# London Luton Airport Expansion

## **8.41 Surface Access Noise Modelling Additional Information**

Application Document Ref: TR020001/APP/8.41

<b>Deadline:</b>	Deadline 3
<b>Planning Inspectorate Scheme Reference:</b>	TR020001
<b>Document Reference:</b>	TR020001/APP/8.41
<b>Author:</b>	Luton Rising

Drawing Number	Revision
LLADCO-3C-AEC-00-00-DR-YE-0001	P02
Project - Phase - Originator - Asset/Zone - Sub Asset - Type- Discp. - Number

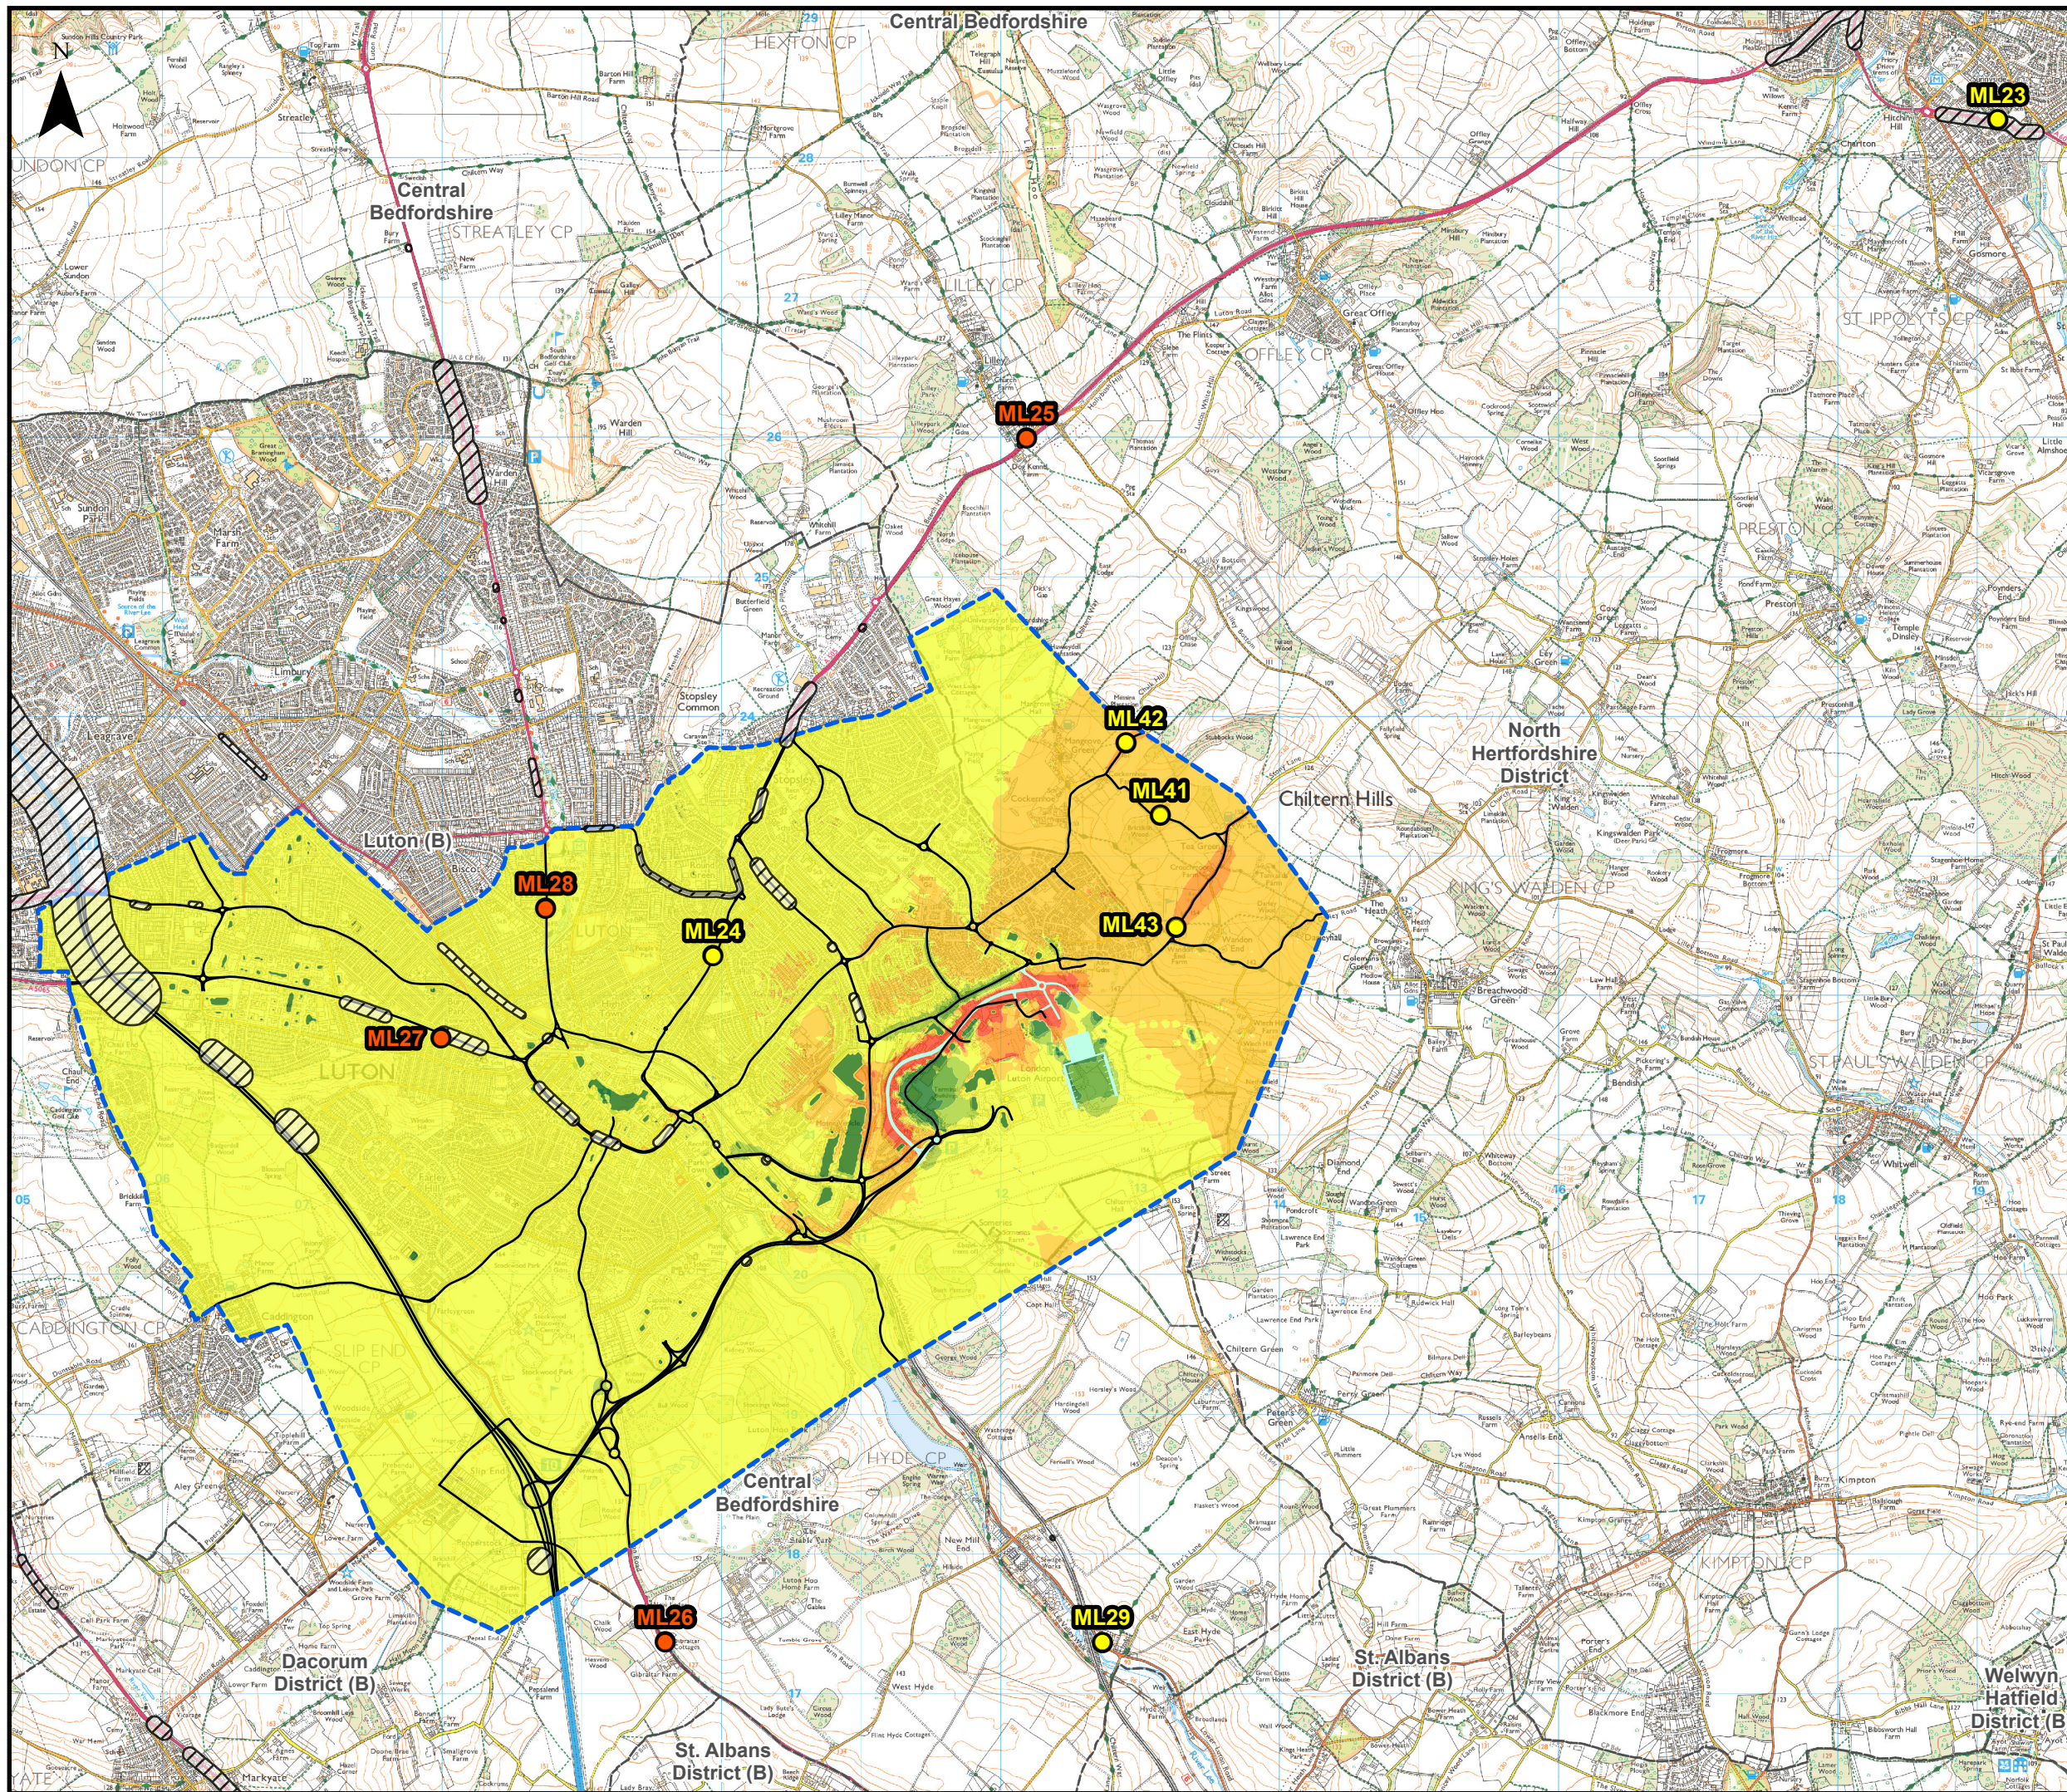
- 3.1.3 The HAs have also queried the validation of the surface access noise model, with references to instances where the measured and predicted values, with respect to the modelled baseline, differ by more than 3 dB. They recommend a clear explanation of these differences, and further justification for why the model can be relied upon.

- 4.2.4 It is noted by the HAs that at four of these 11 locations (ML25-28) the L<sub>Aeq,16h</sub> derived from the measured sound levels differs by more than 3 dB from the L<sub>Aeq,16h</sub> derived from the road traffic noise model.

- 4.2.10 Figure 1 and Figure 2 of this document show the monitoring locations overlaid on the surface access noise change contours for 2043. These figures show that the monitoring locations in question are either in areas expected to experience a negligible change in road traffic noise or outside of the surface access study area entirely<sup>2</sup>. Given that localised corrections to the model would be applicable to both the Do-Minimum and Do-Something scenarios, the only change would be to absolute levels reported in the vicinity of these locations. And as explained in Section 4.1 this would not alter the conclusions of the assessment.

- 5.1.1 Following submission of this paper at Deadline 2, further technical discussions were held between the Applicant and the HAs and their noise consultant. In these sessions, the four monitoring locations that had previously been queried due to discrepancies of greater than 3 dB (ML25-28) were discussed in detail, including a review of the locations using Google Streetview.

- 5.1.2 This exercise identified justifiable reasons for the discrepancies that are specific to the measurement locations and spot check exercise, including:

- a. planned survey locations were used in the spot-check exercise, however for these four locations the actual survey location was slightly updated on the day to due to survey practicalities;

- b. each of the four locations were 3-hour short term measurements which cannot be directly compared to long term annual average weekday model outputs (DMRB itself cautions the comparison of short-term measurements to long-term predictions at paragraph 4.2); and

- c. there were localised road surfacing conditions for each of the four locations that would influence the noise levels.
- 5.1.3 Following this exercise, the spot check exercise was repeated with the corrected actual survey locations, and details of the road surfacing conditions were provided to the HAs in writing, as per **Table 5.1**. As a result, it was agreed between the Applicant and the HA's noise consultant that the discrepancies are due to locations specific factors, and it was agreed that the surface access noise model is appropriate. This will be recorded in the next update of the Statements of Common Ground.

- 5.1.4 Figure 1 and Figure 2 within this document have been updated with the corrected survey locations (this has only affected ML25-28).
